Date: 25 June 2018
Our ref: 14677/SSL/JL/15983452v1
Your ref: AL/20/18/OUT

Representations in relation to application (ref. AL/20/18/OUT) for outline planning permission for up to 27 dwellings at Bridge Cottage & The Old Cottage Lidsey Road, Lidsey, PO22 9PH

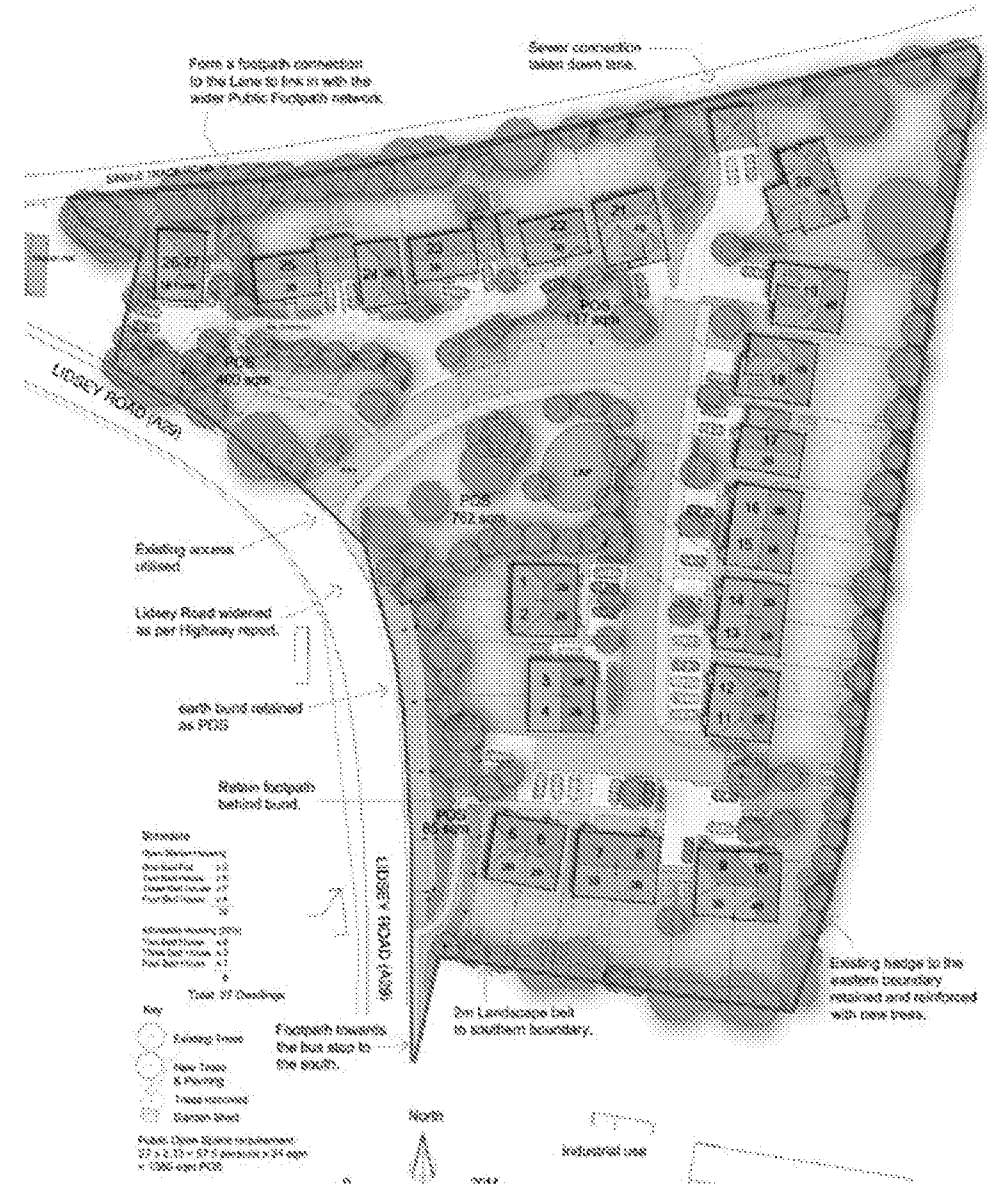
First, we do not support the Illustrative Site Plan or Block Plan (drawing ref. 1749-02B / 1749-03). The planning application is in outline form with all matters reserved, except access, the Illustrative Site Plan and Block Plan fails to offer east west connections into the wider BEW site as required by emerging Policy H SP2c SD5 and does not successfully tie into the pedestrian and cycle connections in the wider area. It is important that these matters are considered prior to determination to ensure that the proposed development does not miss an opportunity to integrate with the wider BEW masterplan at the appropriate time.
